11 September, 2012

STATE SIGNIFICANT INFRASTRUCTURE – HEXHAM RELIEF ROADS PROJECT (SSI-4992)

I refer to the Department's letter of 7 August, 2012, inviting Council to comment on the Environmental Impact Statement (EIS) prepared by KMH Environmental in support of the abovementioned Project.

ARTC
Hexham Relief Roads
**Zoning Map under
Newcastle LEP 2012
& Port Stephens LEP 2000**

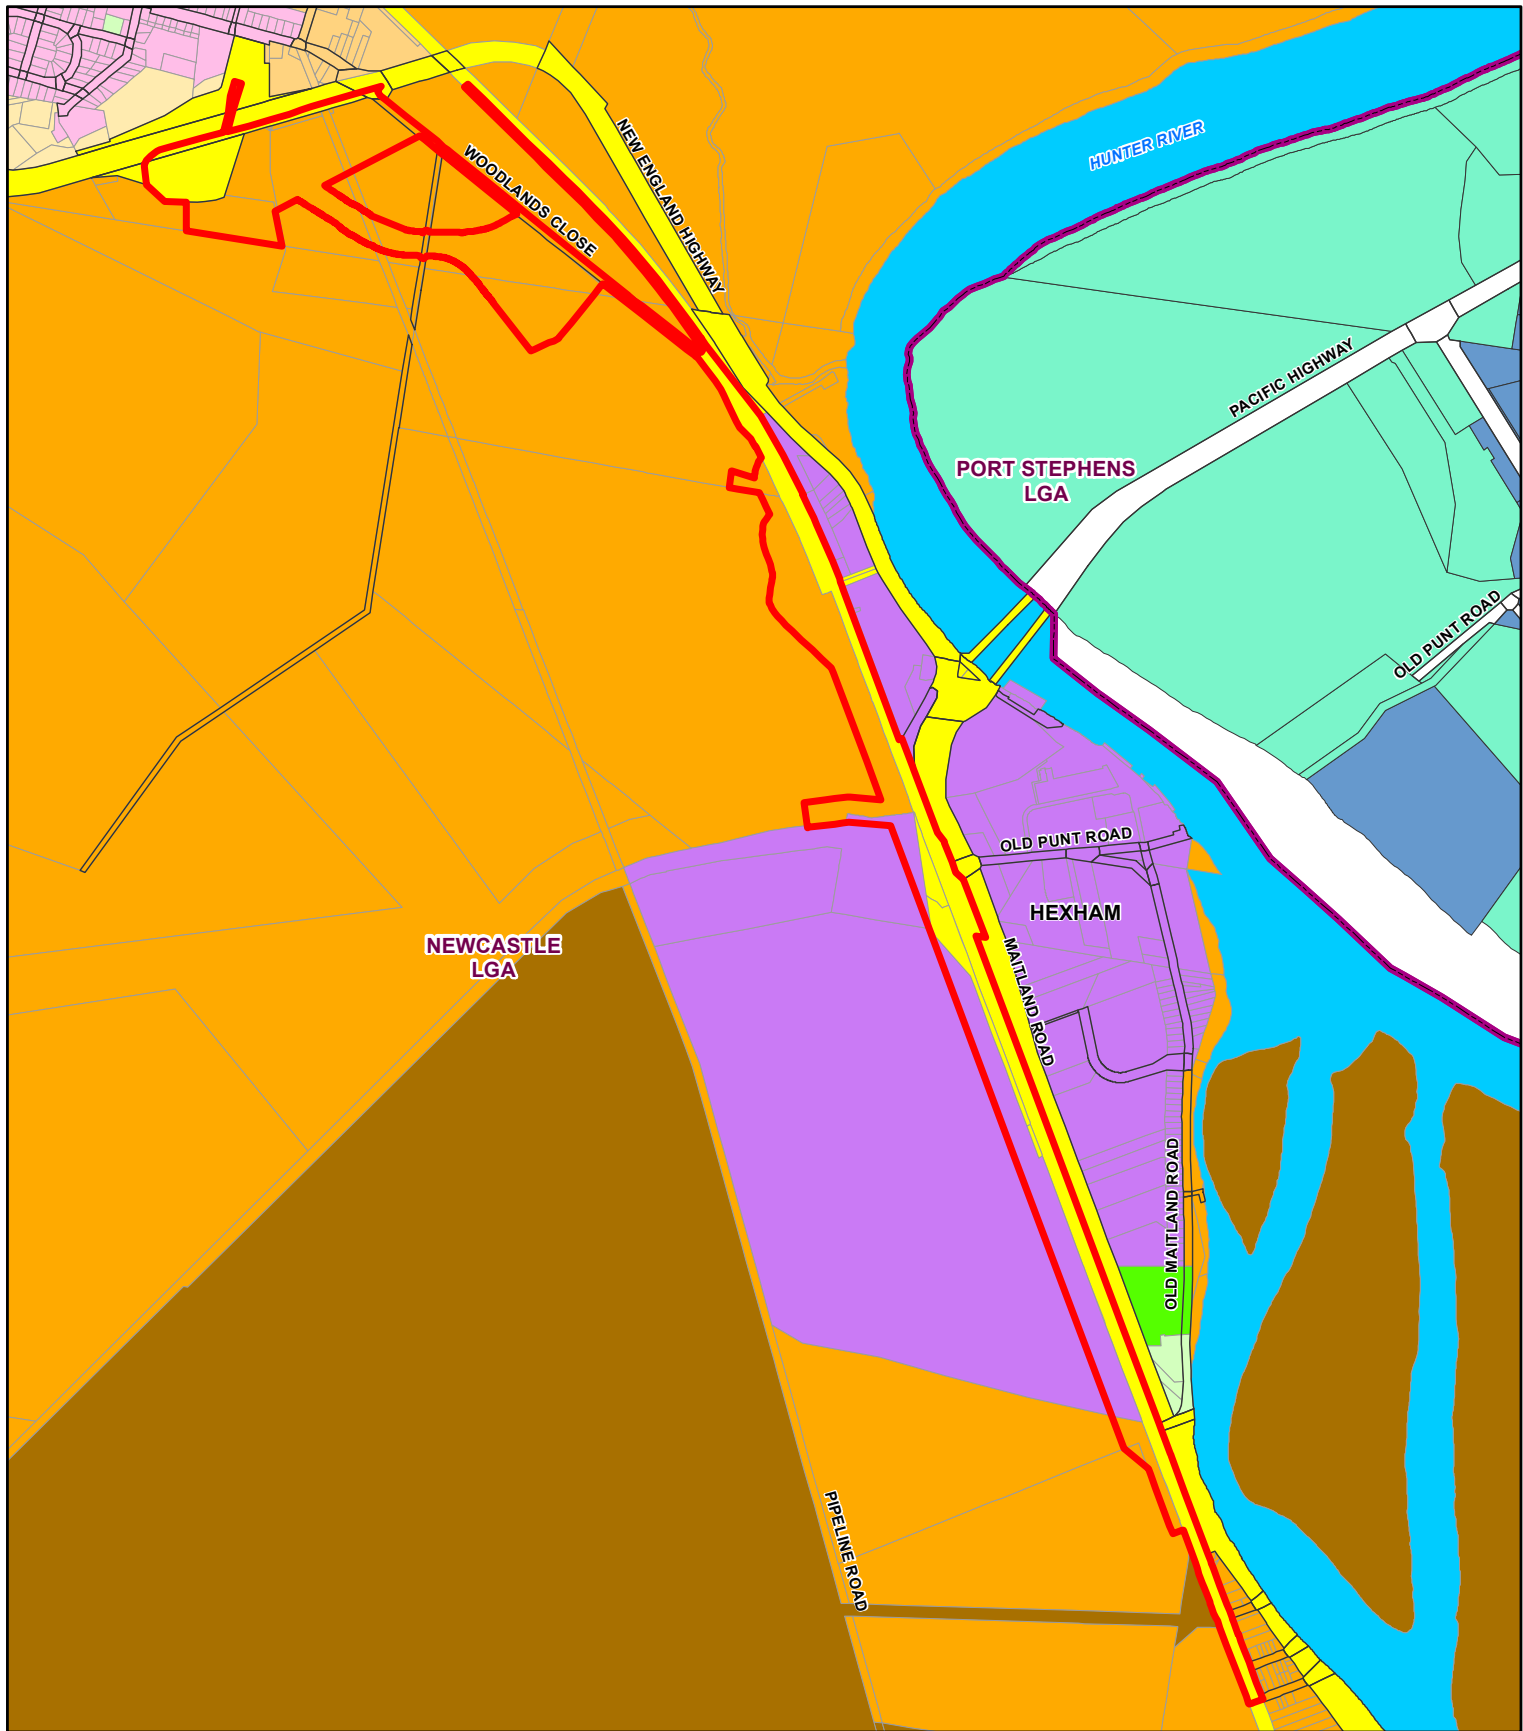
However, the Director-General's requirements required the EIS to consider the relevant Local Environment Plan. Under the Newcastle LEP (NLEP), 2012 the Project is within land zoned SP2 Infrastructure, E2 Environmental Conservation, E1 National Parks and Nature Reserves and IN3 Heavy Industrial. The EIS has not discussed the permissibility of the Project in respect of the above zones or compliance with relevant objectives of the Plan. Also, the EIS does not include a plan/figure that identifies the extent of the Project site relative to the boundaries of the four zones.

Figure 4.1 Proposed temporary construction access road connecting with the Tarro Interchange and a median barrier on Anderson Drive

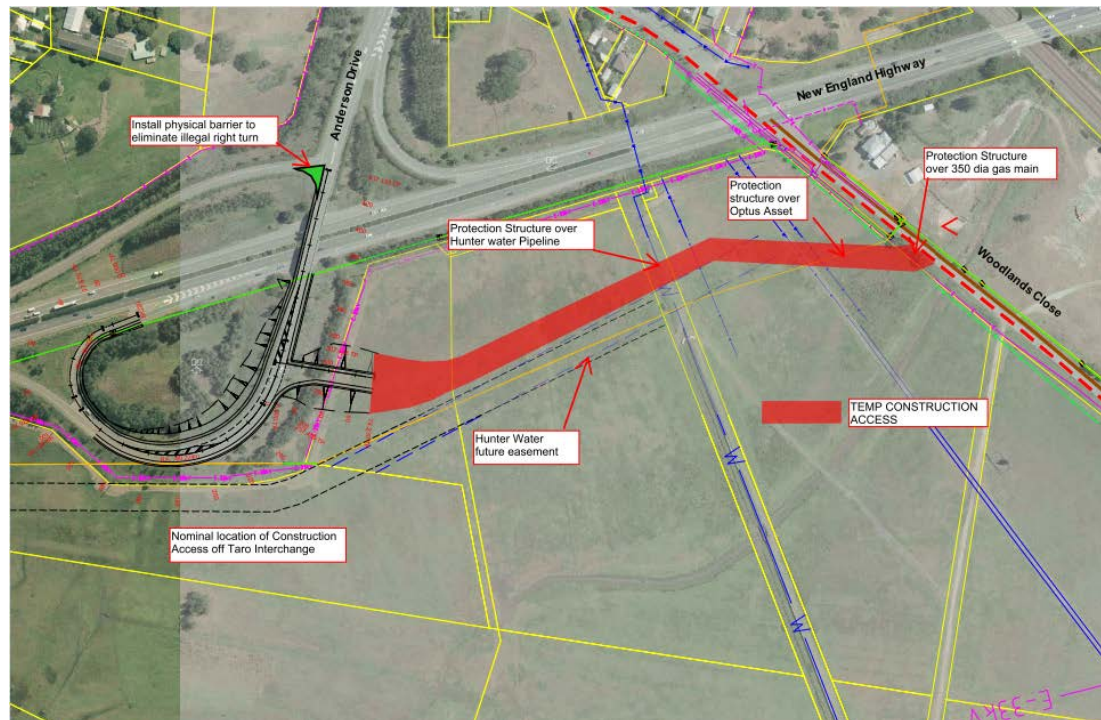
- (d) The temporary Tarro interchange access road is proposed to be an informal gravel road. It is recommended that this road be a sealed all-weather road to minimise dust and prevent erosion.

- (e) A typical cross-section profile should be provided in relation to the temporary Tarro interchange access road, inclusive of the estimated height/width of embankments and location of vehicle safety barriers. While the road is temporary it will be required to be designed to current road safety design standards.

Figure 4.2 Proposed haulage routes

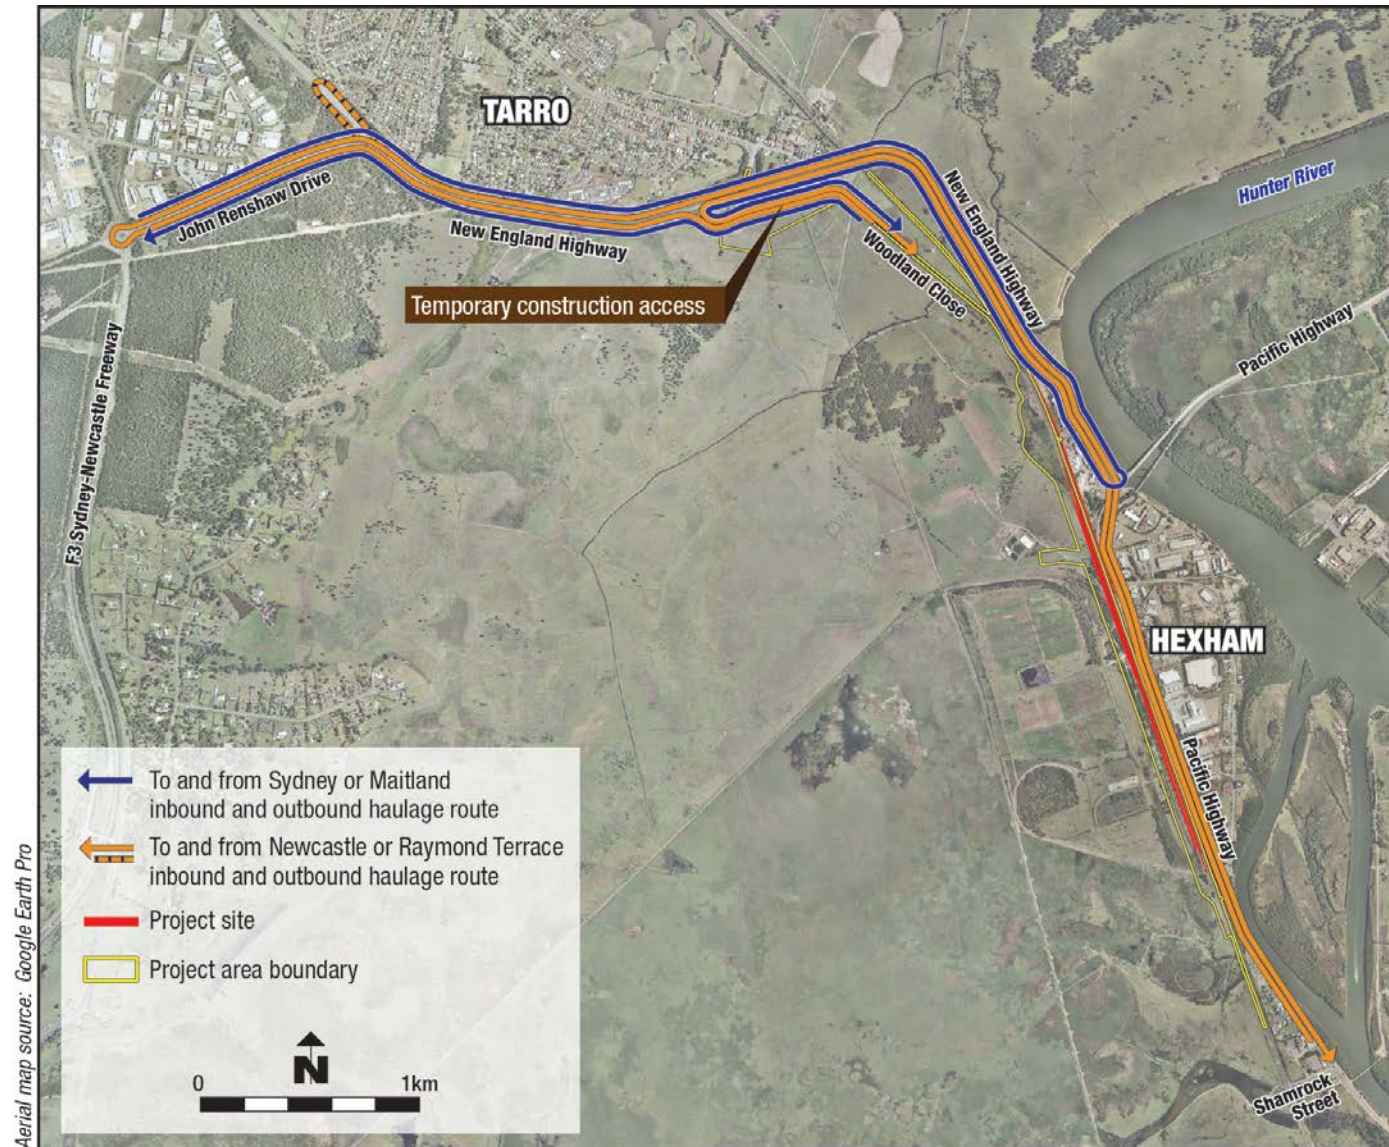
- (c) The nominated haulage routes include the use of the existing U-turn facility located 400m north-west of the John Renshaw Drive turn-off. This U-turn facility would appear to not adequately cater for heavy vehicles.

Figure 6.1 Proposed sketch layout of Anderson Drive intersection with the temporary construction access road

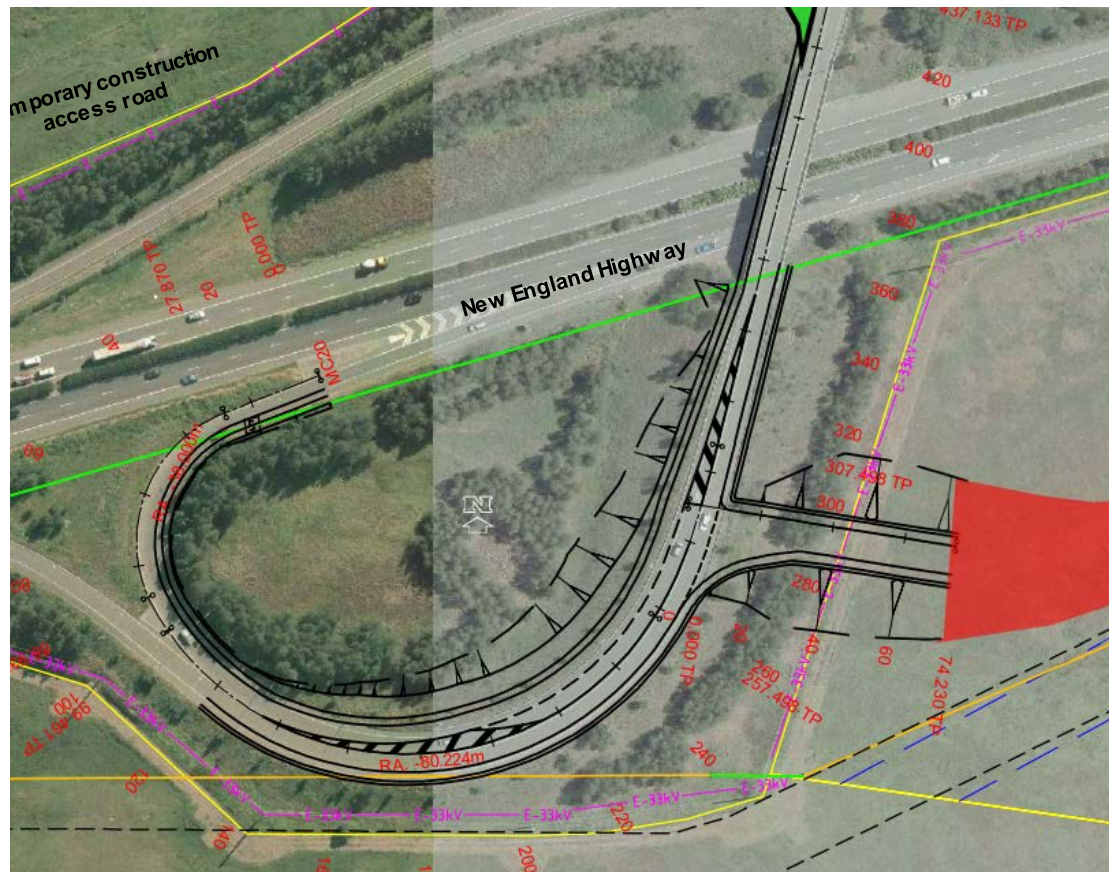
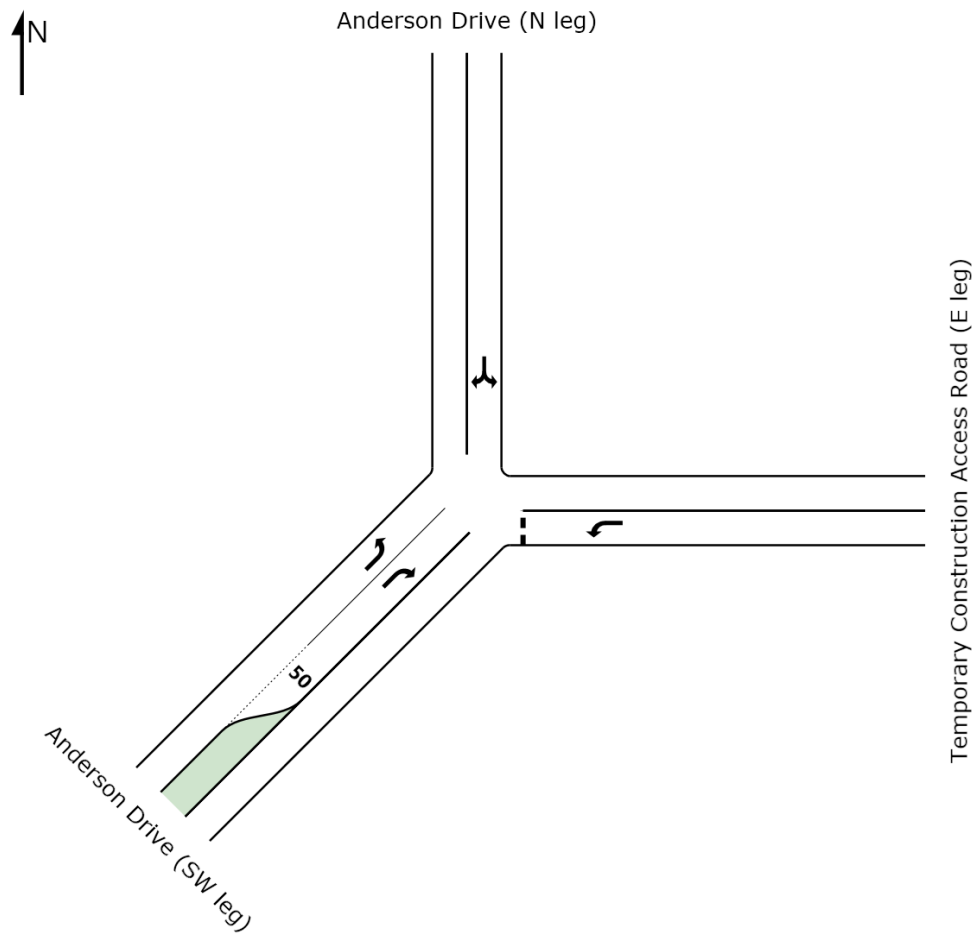
- (h) Section 6.42 – 'Road Safety Impacts' of the Traffic Impact Assessment states that head-on collisions may occur on Anderson Drive due to the new intersection not having sufficient space to accommodate large vehicles. This is considered unacceptable and either the intersection needs to be modified to accommodate these vehicles or if the use of these vehicles is infrequent then appropriate traffic control outside of peak periods could be utilised, subject to RMS approval. The proponent needs to define the vehicle type being referenced as a 'large vehicle'.
